PLANNING CONSULTATION RESPONSE

Application No	2025/0961
Proposal	2025 0961 C of U Vacant Chapel (Class F1) to Self-Storage (Class B8) Old Wesleyan Chapel Hoyland Road Hoyland Common
Address	Old Wesleyan Chapel Hoyland Road Hoyland Common
Date of Consultation Reply	18.12.25
Consultee	Tony Wiles Senior Conservation Officer

Consultation Assessment and Justification

Proposed GA Section
Scale 1:50

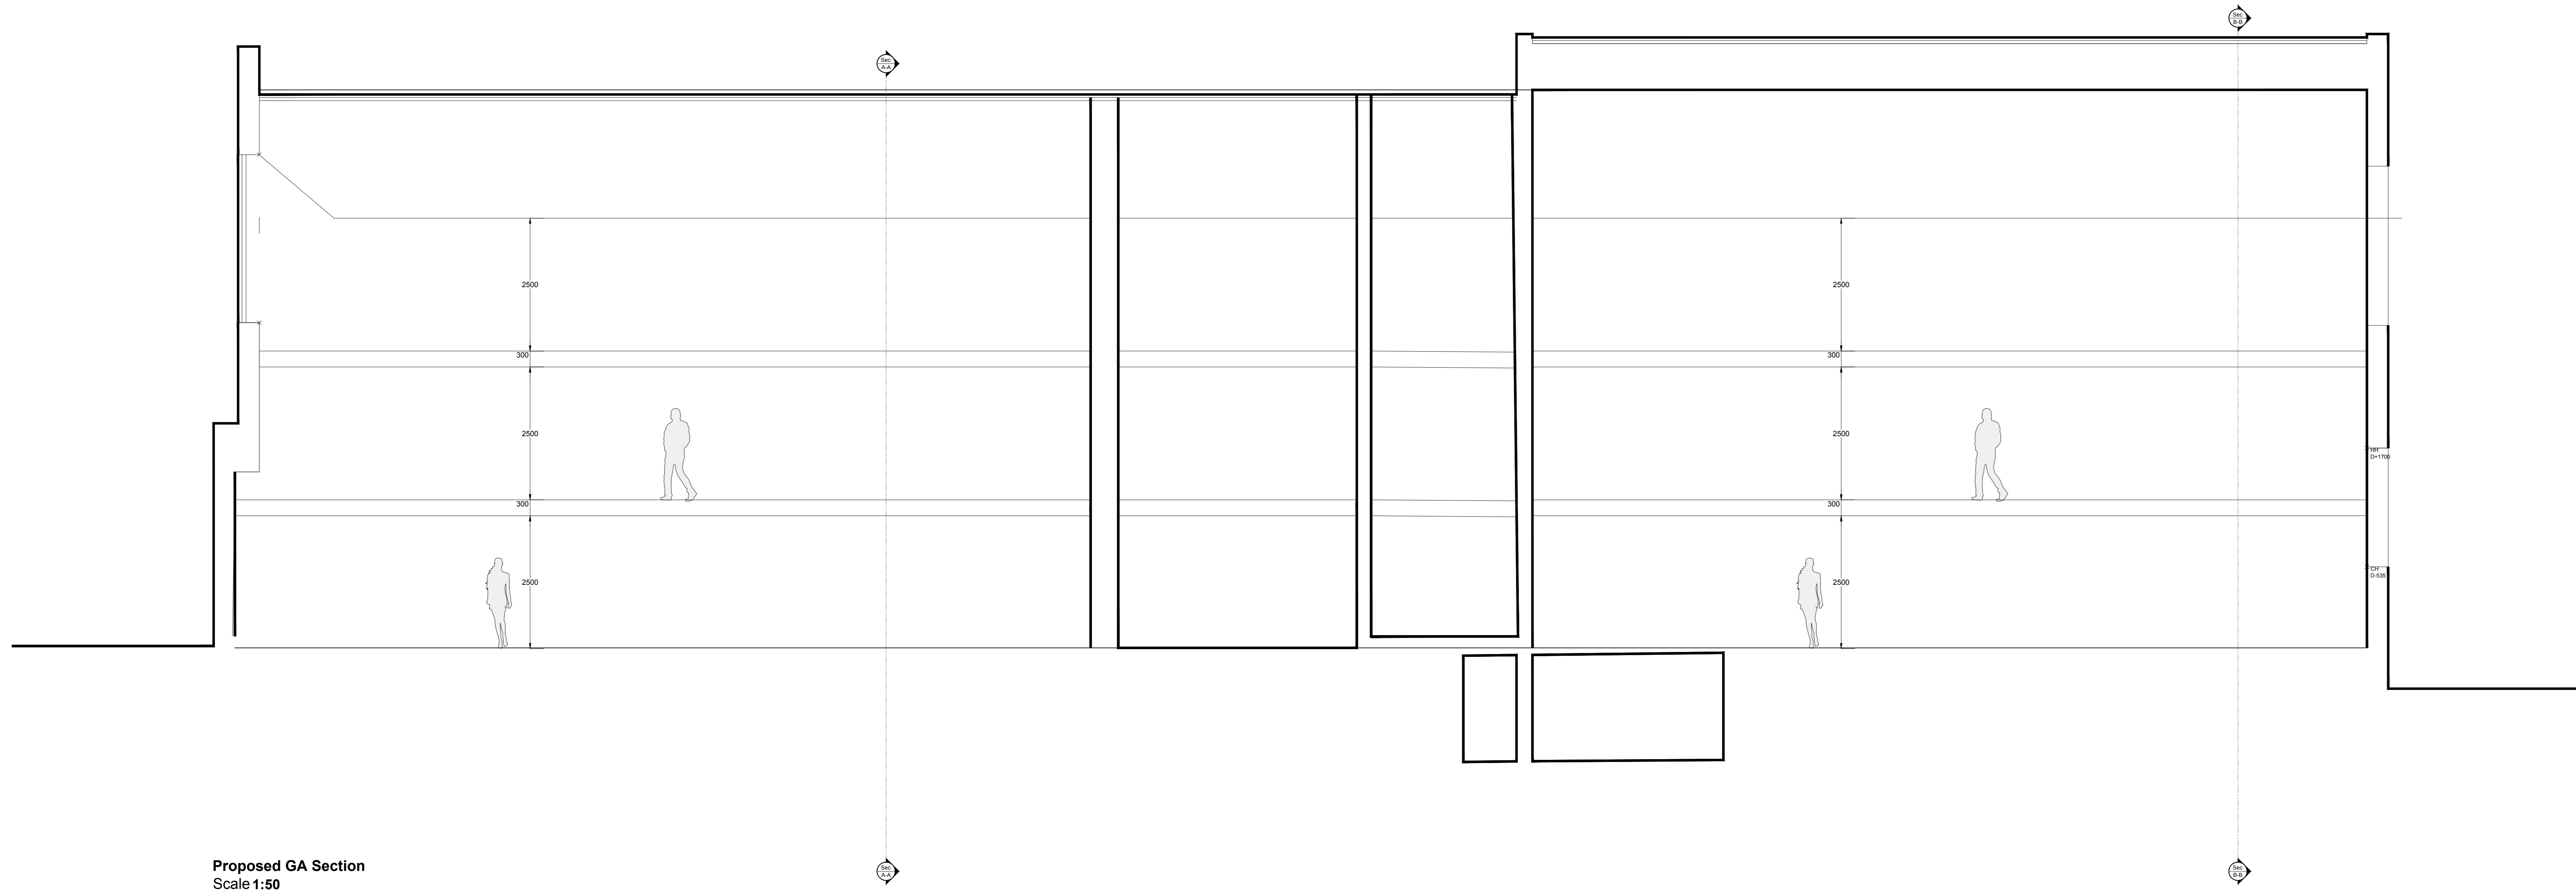
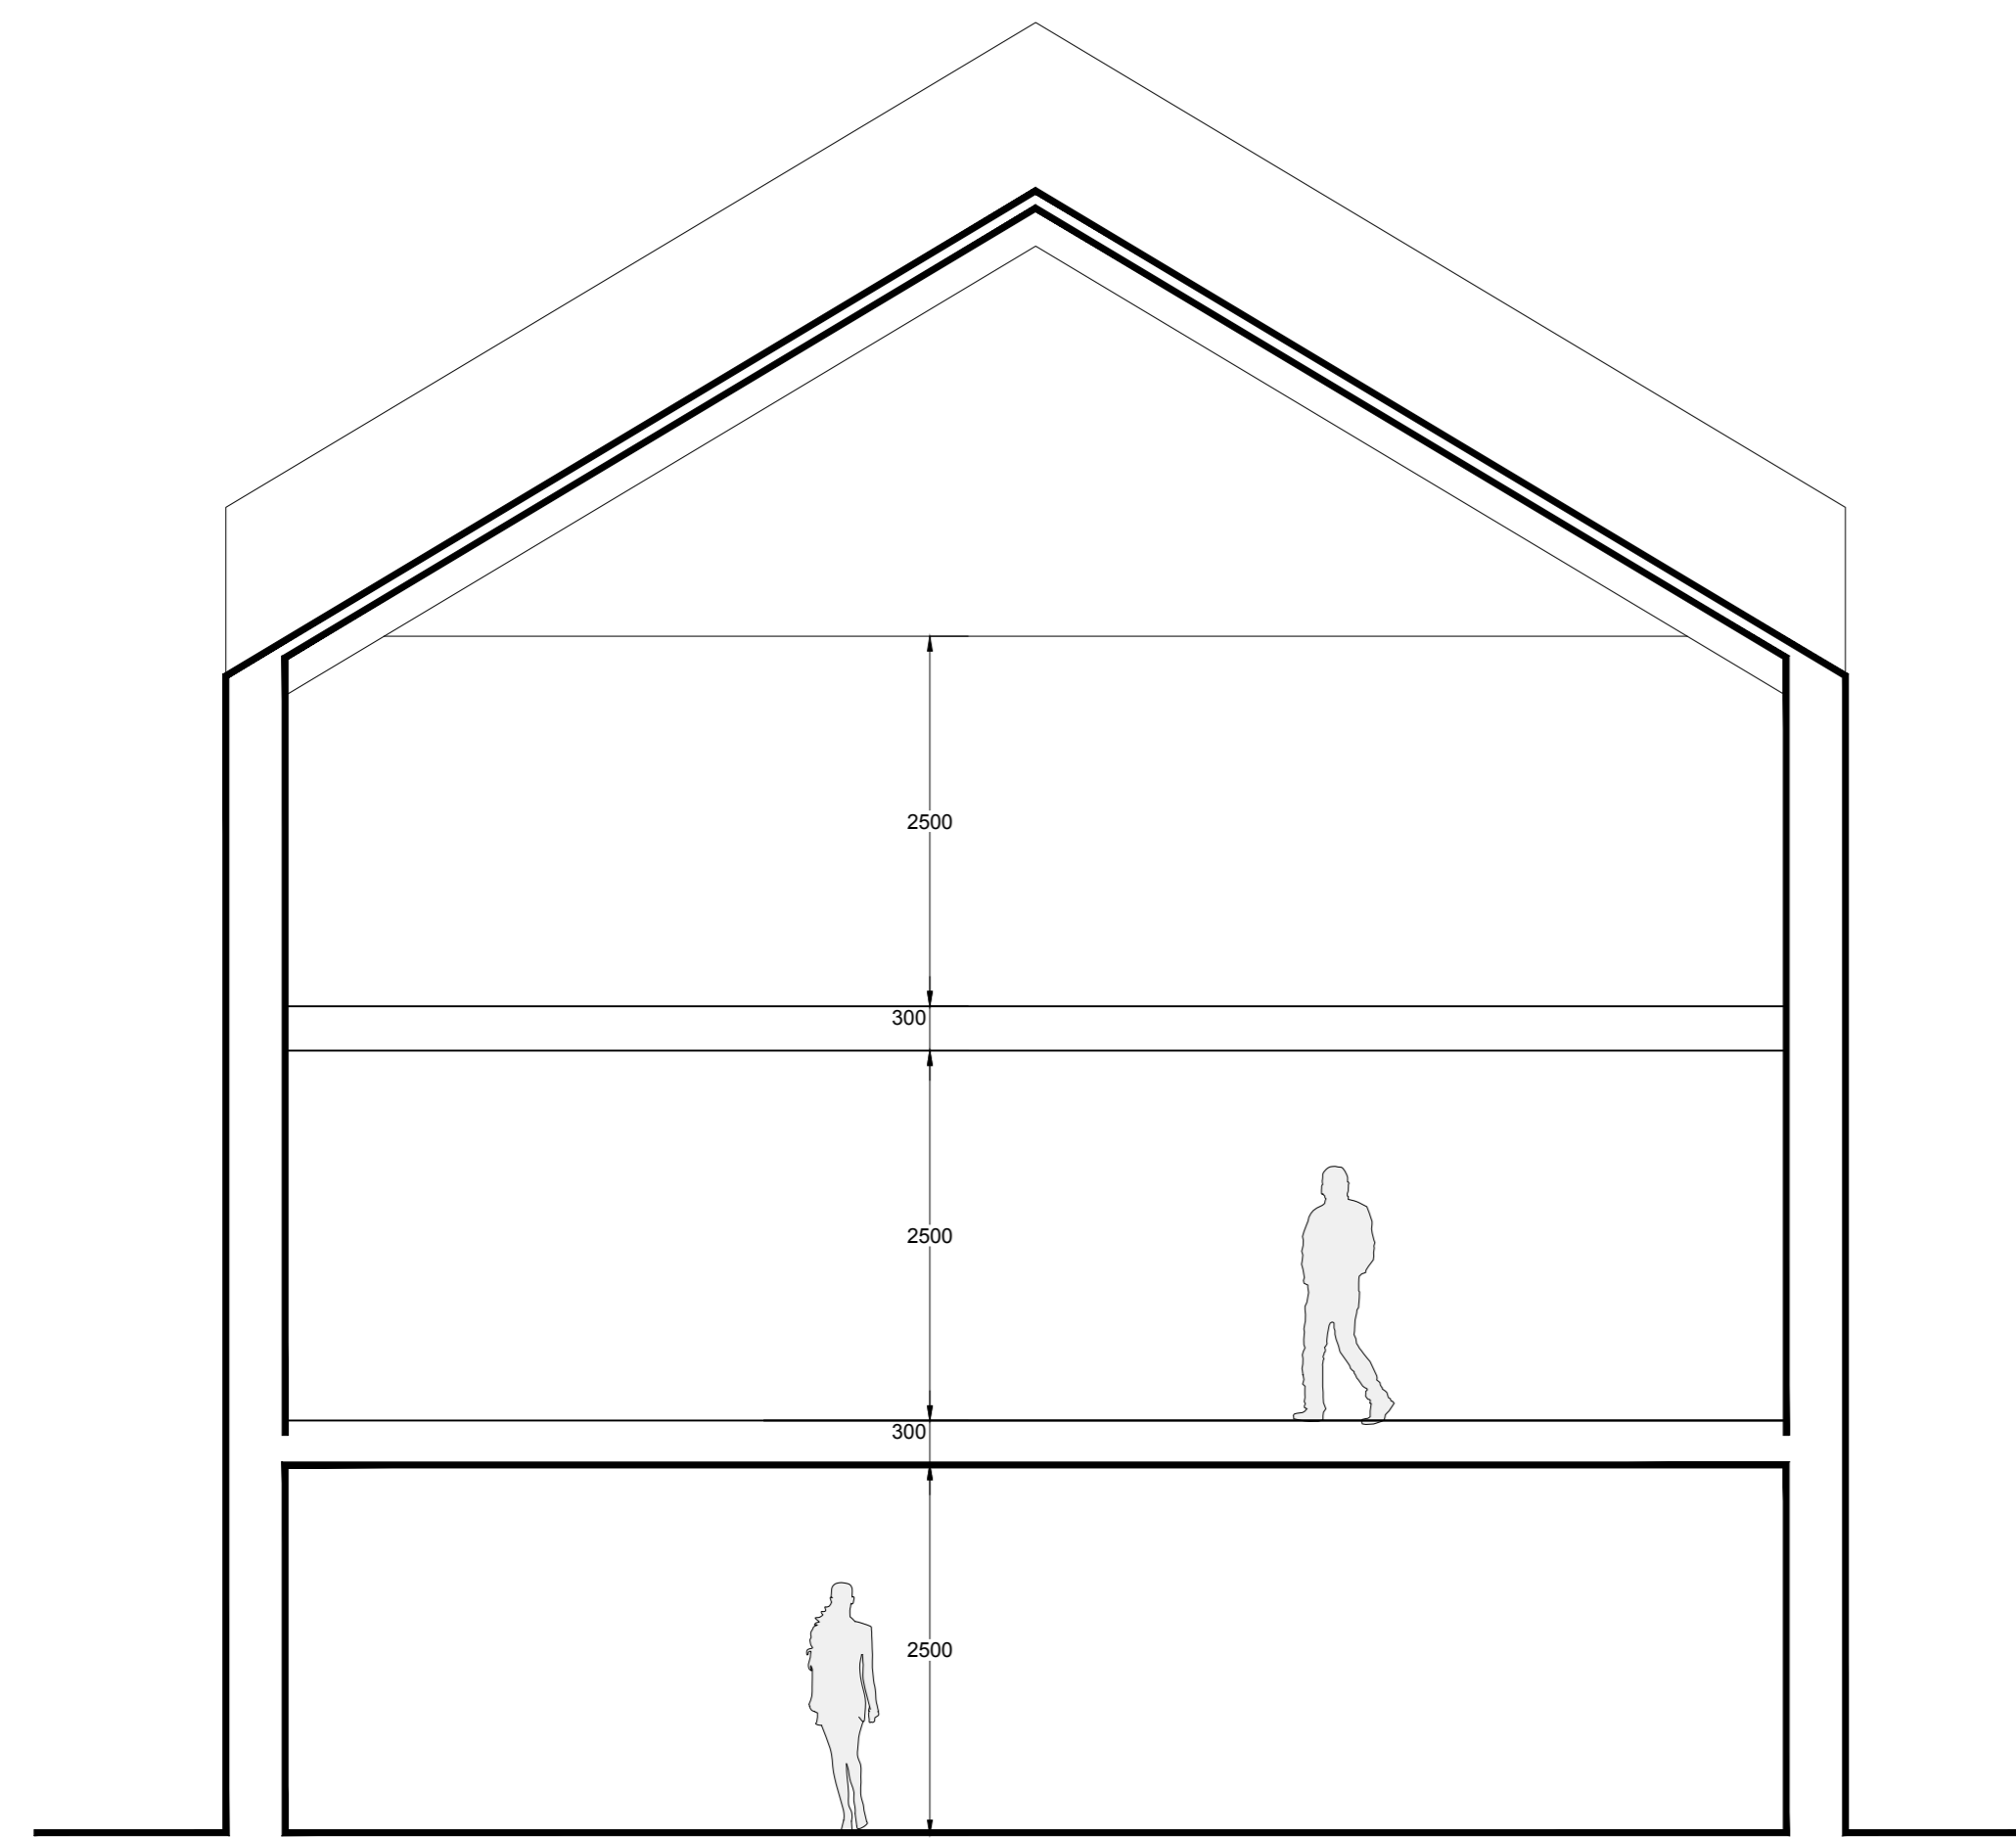
This application requests permission to change the use of the former Wesleyan Chapel on Hoyland Road, Hoyland Common from a place of worship to B8 – self storage. The proposal proposes no external alterations, but internally the auditorium and worship space will be demolished with a first and second floor inserted to provide storage space.

Externally, the chapel has an imposing stone-built frontage facing north onto Hoyland Road. This elevation retains much of its original detail, including a three bay / two (large) storey façade with a Flemish Gable, and a pediment at its apex. Smaller carved pediments top openings at ground floor level and there is a later porch (with pedimented inscribed date stone) covering a large three light mullioned opening (the top of which is just visible). At first floor level the windows are arched with voussoirs and the original frames and stained glass appear to be in situ. The side and rear elevations are much plainer and forgo ornamental detail for a robust but simple vernacular style in coursed stone with stone heads and cills. The roof retains its original Welsh Slate Covering. Whilst I know nothing of the interior or the condition of the building inside beyond its general layout, I can see from the plans it appears to retain its original auditorium, stage, and upper seating areas within. In terms of its character and quality I'd class the building as a non-designated heritage asset of some local value. Listed Wesleyan Chapels are somewhat rare in Barnsley but include the Salem Reform Chapel in Barnsley town and the United Methodist Free Chapel on Spark Lane. As such I feel this chapel is unlikely to be worthy of national listing. However, the front elevation is clearly of some quality and despite its condition contributes positively to the street scene. If it were in a decent state of repair, the building would obviously contribute far more. In terms of the internal changes, I would need to know more about the condition and degree of survival of original features to pass judgement on the proposal and whether total internal demolition and replacement is justified. I understand the building appears to have been vacant for some time following its former use as a kitchen showroom. As such, a new use that preserves the building fabric and its overall survival may be acceptable. However, this would need a fair degree of justification if that survival involved the wholesale loss of the internal worship space its existing plan form / arrangement or other features of merit.
